From: Shephard Tania
Sent: Friday, 16 December 2011 3:49 PM
To: 'diana.marder@planning.nsw.gov.au'
Subject: Re: Modification to Lot 5 of Interlink Industrial Estate at Lot 141 DP 843899 Mamre Road, Erskine Park

I refer to your letter dated 23 November 2011 concerning the above modification application. The following comments are made with respect to the application:

Site Plan

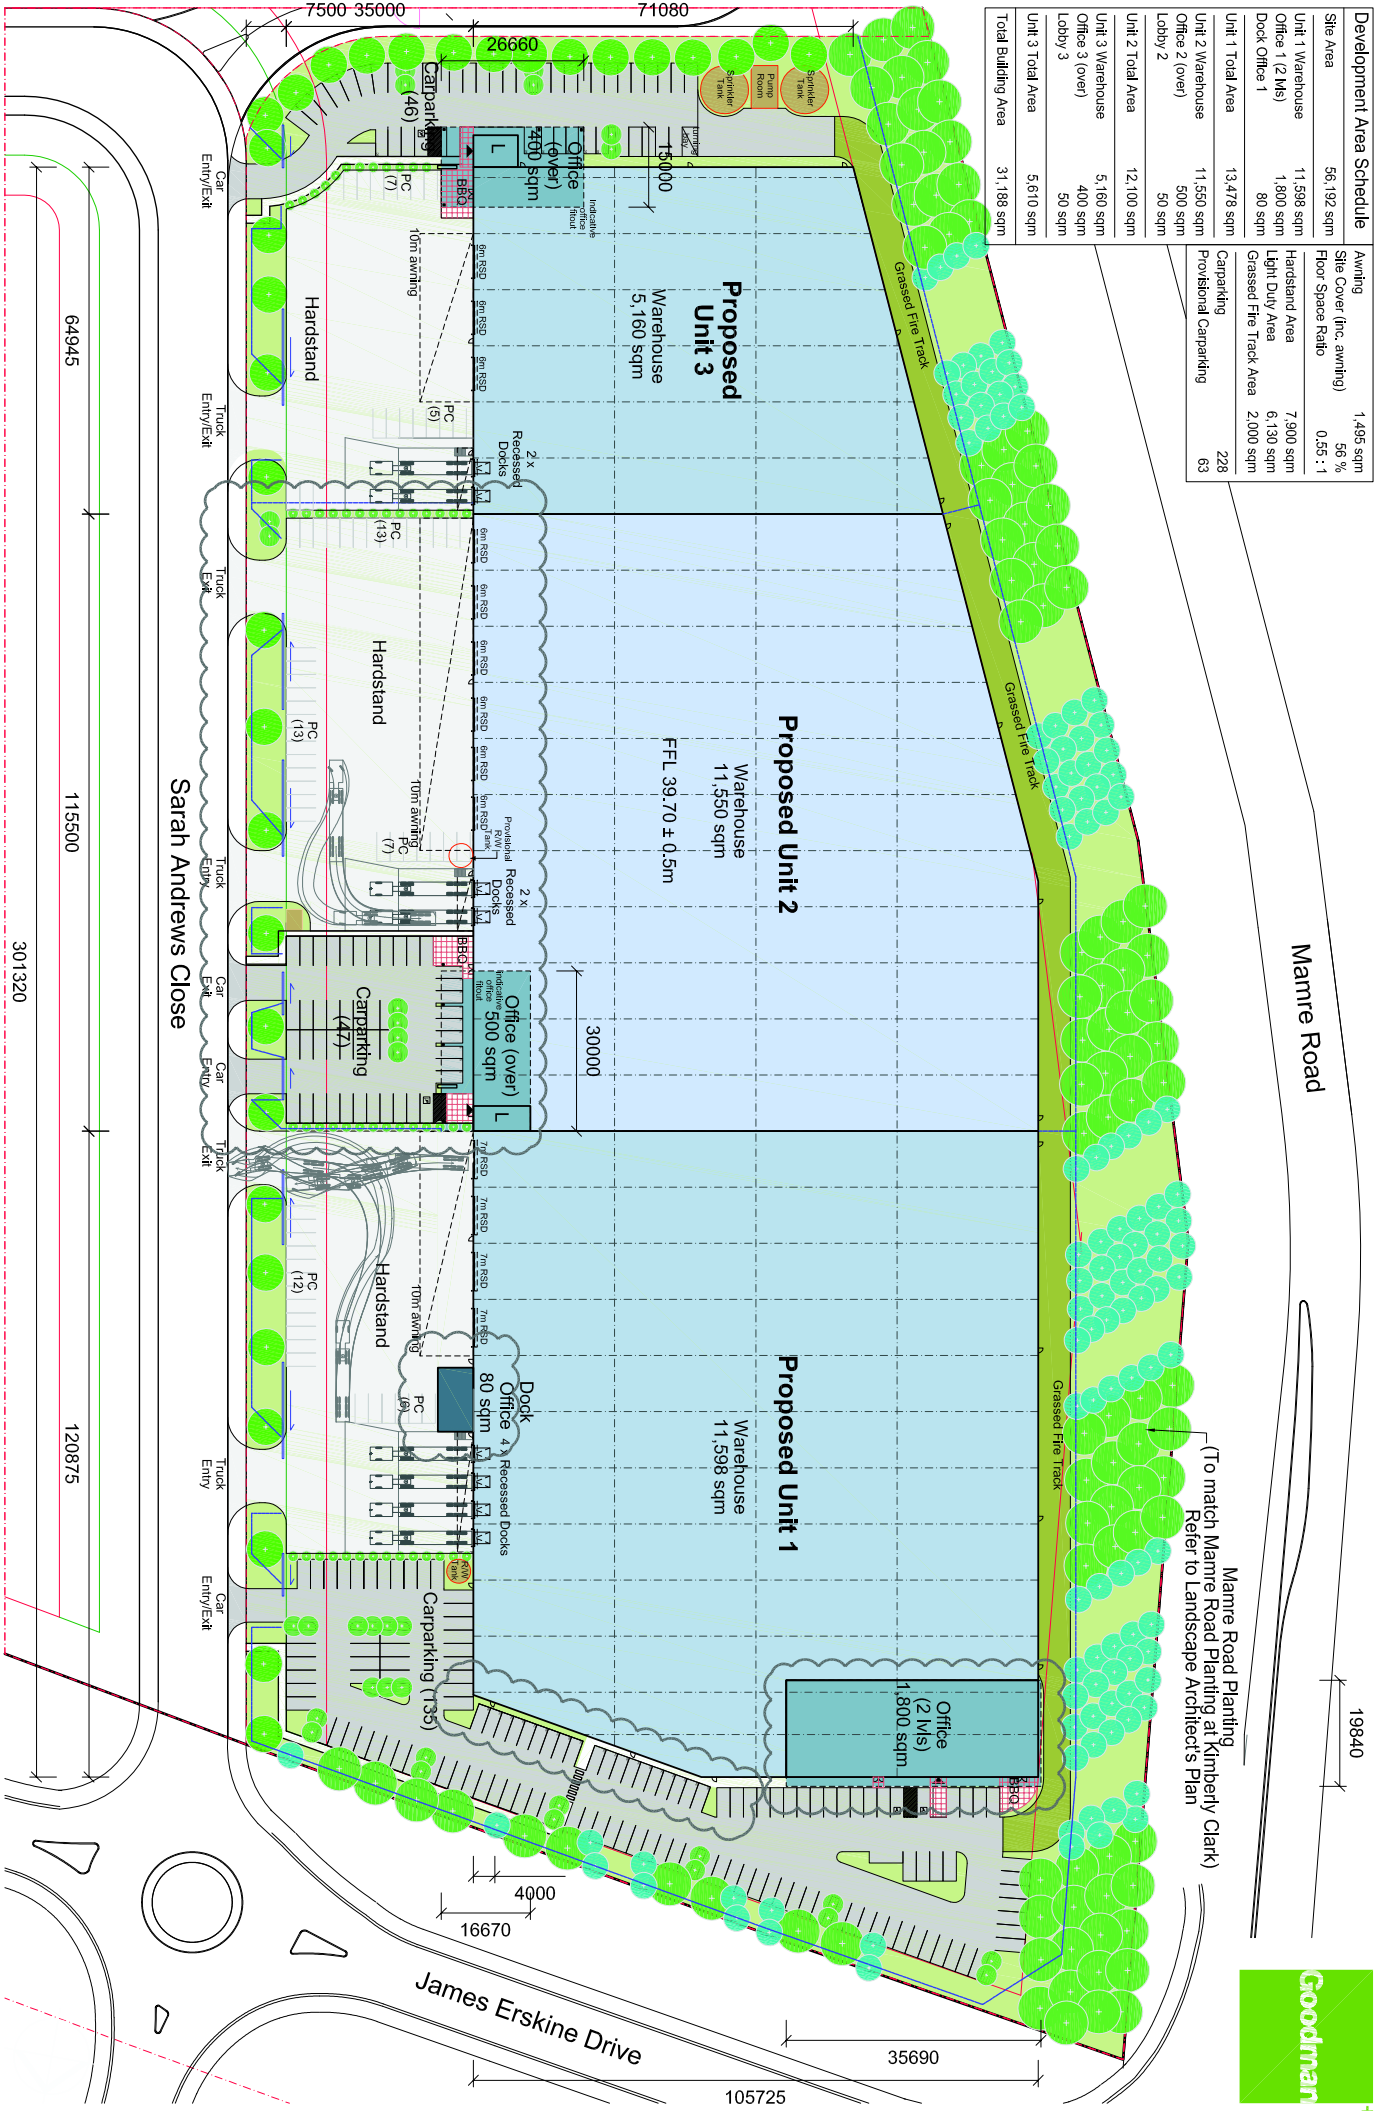
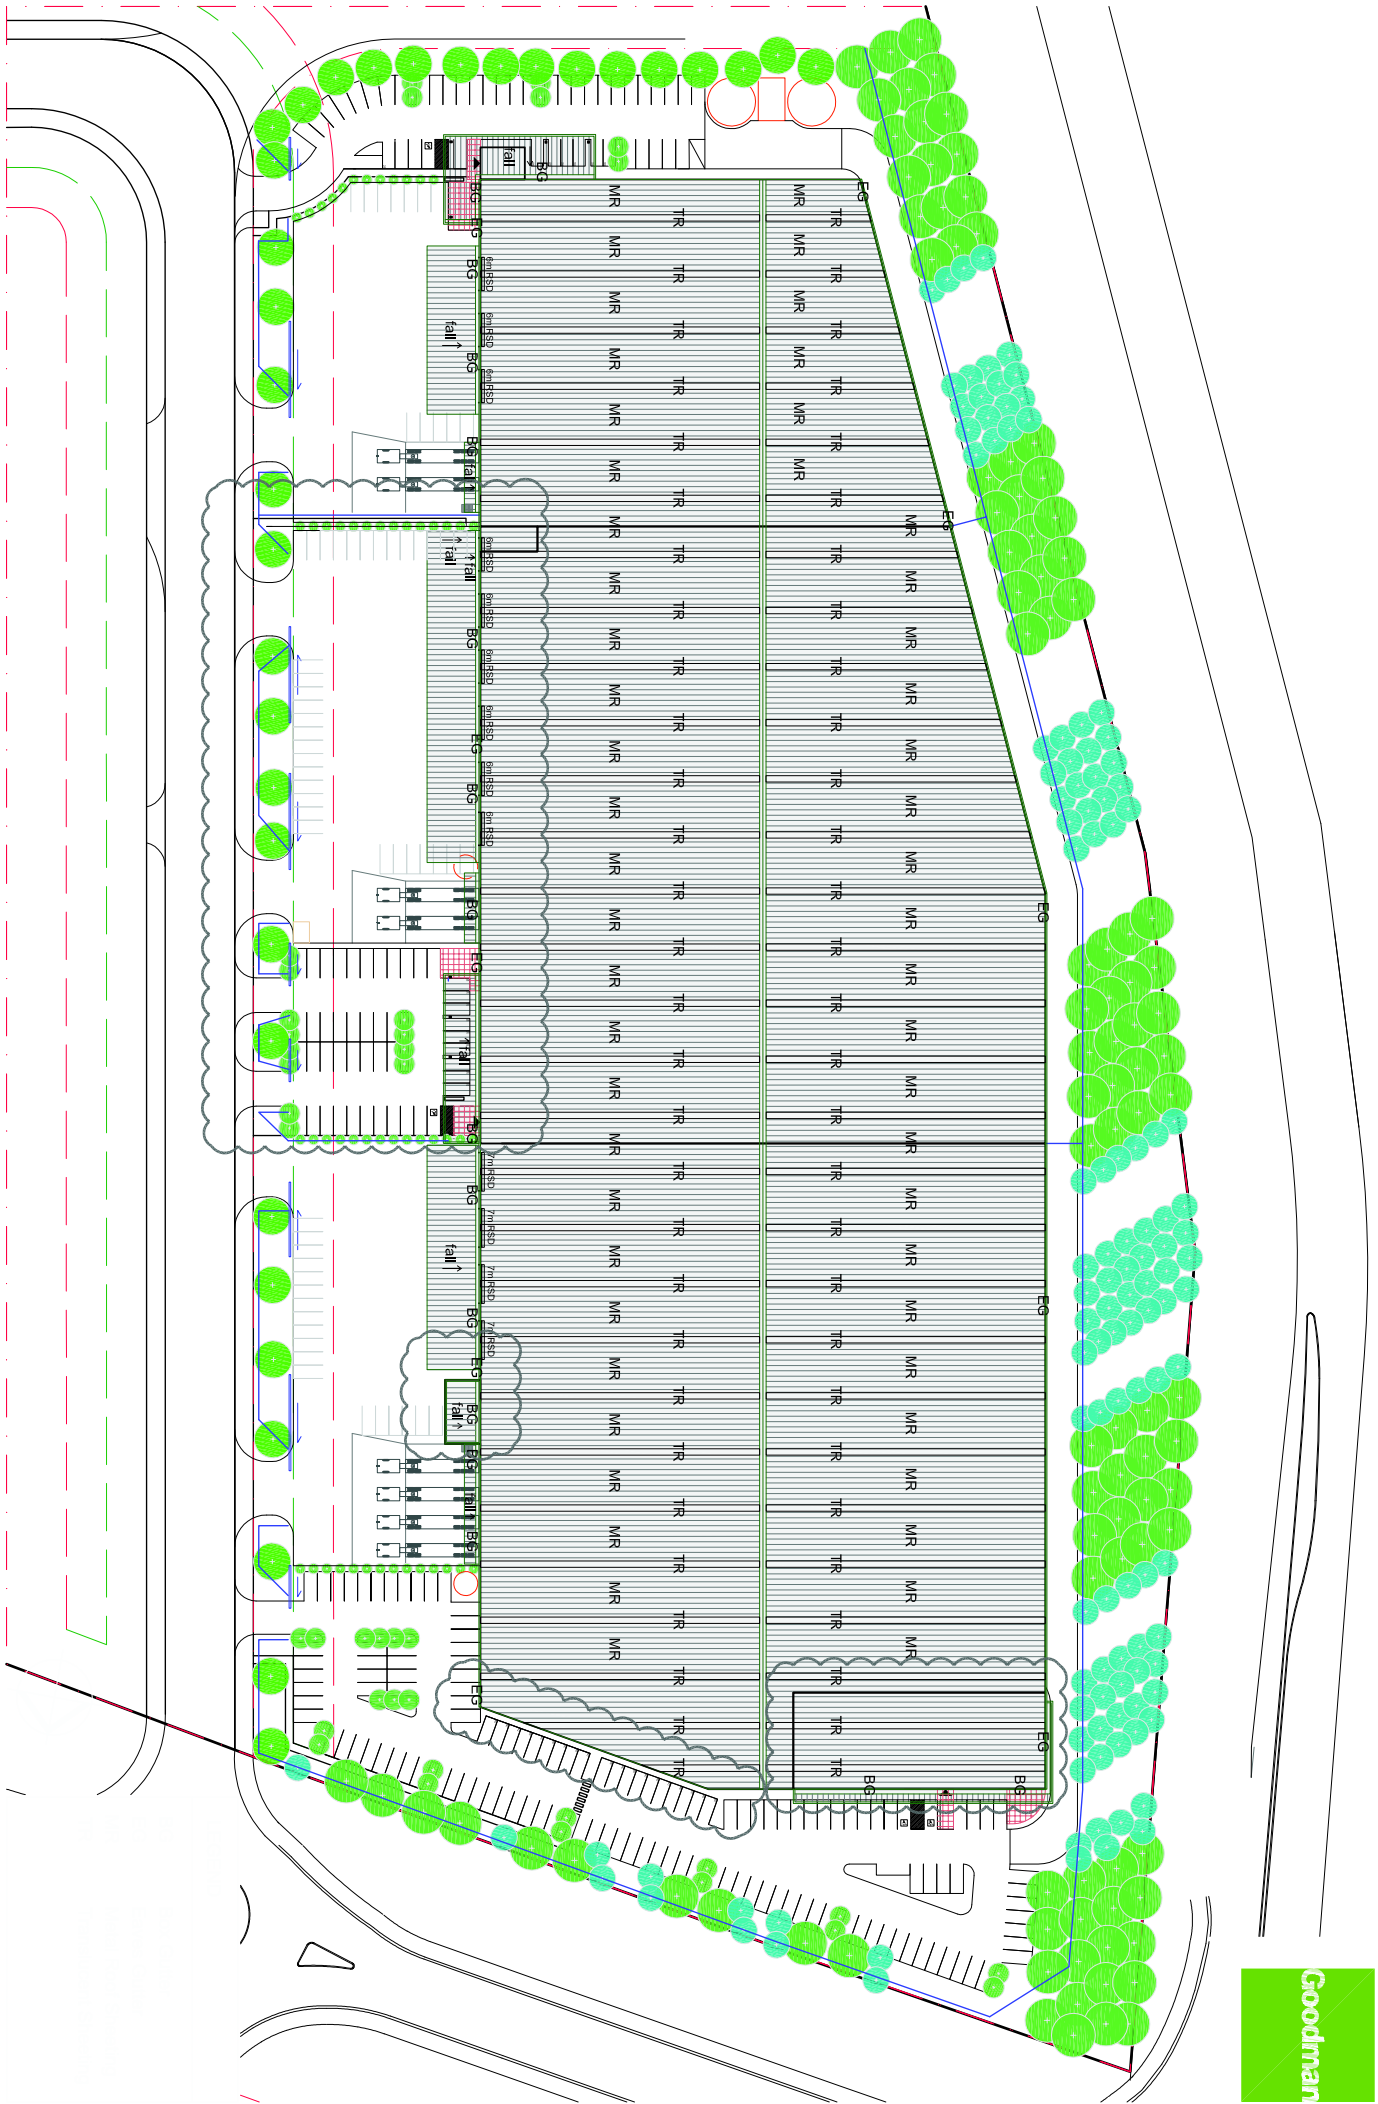
- The proposed development fails to satisfy Council's minimum requirements with respect to car parking rates. The arguments that the previously approved car parking rate could be applied to the proposed development form may not be appropriate given that car parking demands vary based on land use types and unit sizes. An appropriate ratio of car parking numbers is to be provided for each unit within the development.

West (Mamre Road) Elevation - PROPOSED Modification

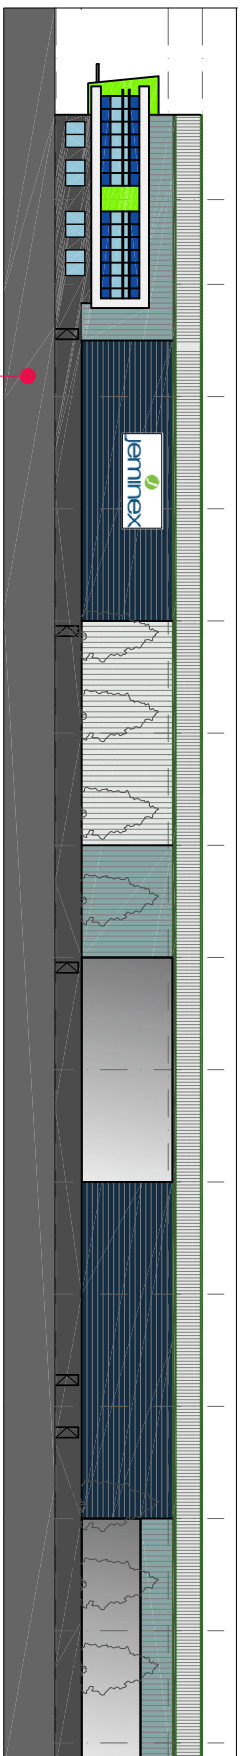
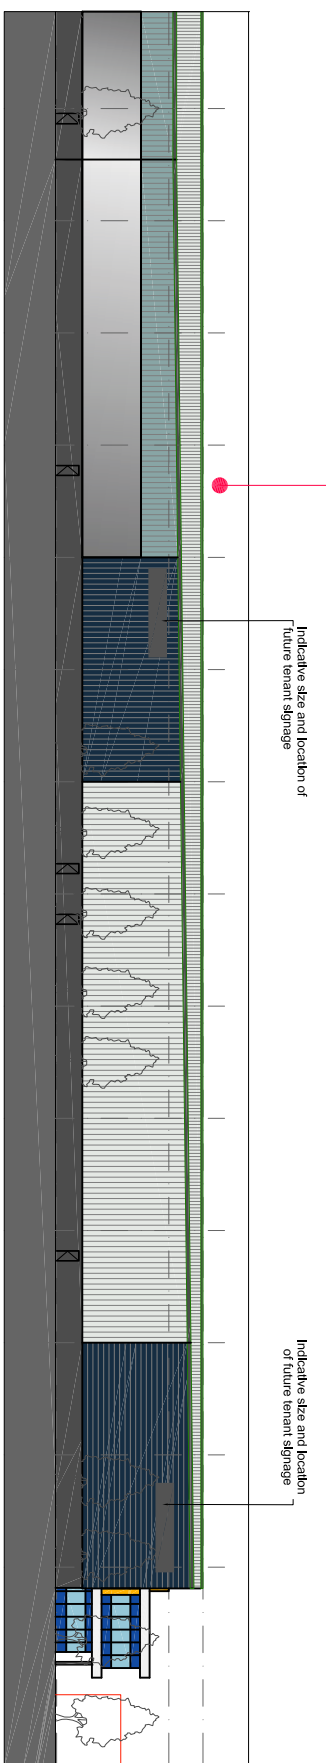
- Council's immediate concerns with the modifications relate to the size of the building form proposed and the visual impact of such. Council requests that particular attention be given to the visual impact of the development as viewed from Mamre Road. The proposed consolidation of buildings results in a significant built form with respect to bulk and scale. Appropriate articulation of the building form is to be provided and the requirements for site development and urban design as contained in Section 6.10 (Erskine Business Park) of Penrith Council's Development Control Plan 2006 (DCP 2006) are referred to in this regard. The use of appropriate and varying building materials and colours is encouraged.

INTERLINK INDUSTRIAL ESTATE
MAMRE ROAD; ERSKINE PARK
LANDSCAPE CONCEPT PLAN

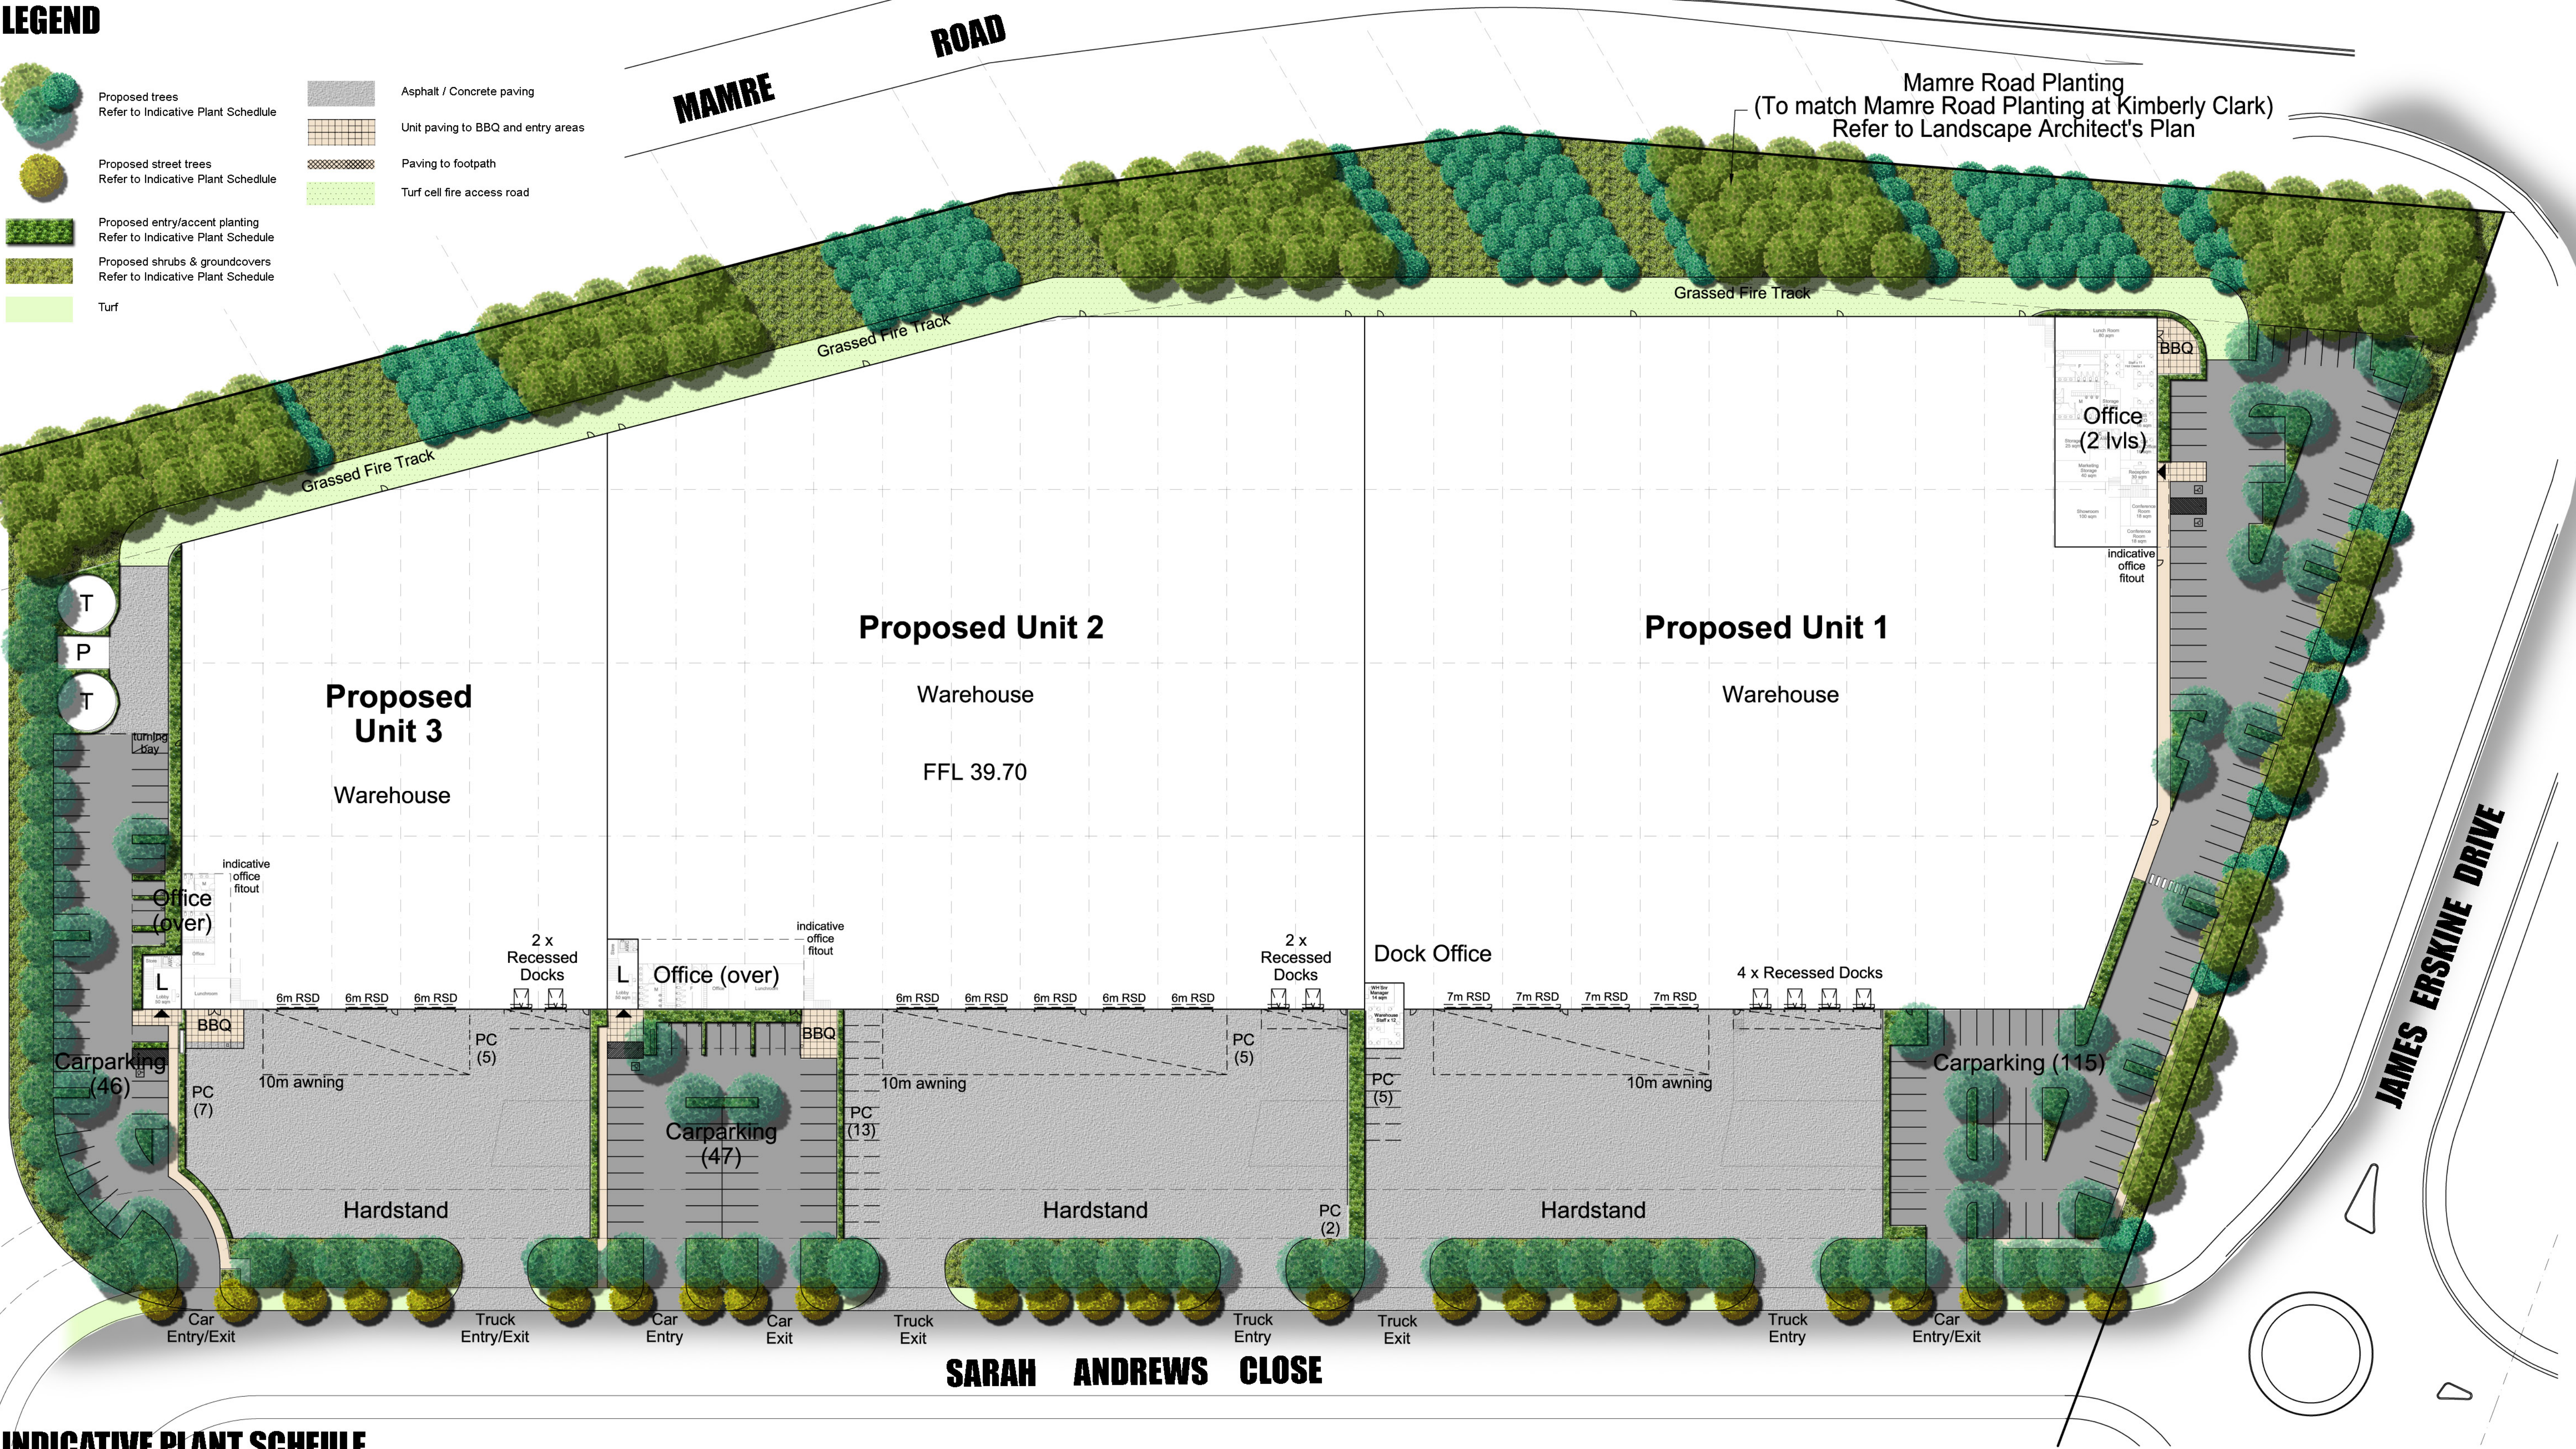
- Further to the above, the requirements for landscaping contained in Section 6.10 of DCP 2006 should be considered in the design of any landscape plans for the site. Landscaping should be designed to complement the development and reduce the visual impact of the building when viewed from Mamre Road. As noted in DCP 2006, *"the visual impact of large expanses of wall should be reduced in scale by architectural treatment as well as by dense grove planting or other landscape design solutions"*. (It is considered that the provision of a "turf cell" fire track need not compromise Council's objectives for landscaping along Mamre Road.)
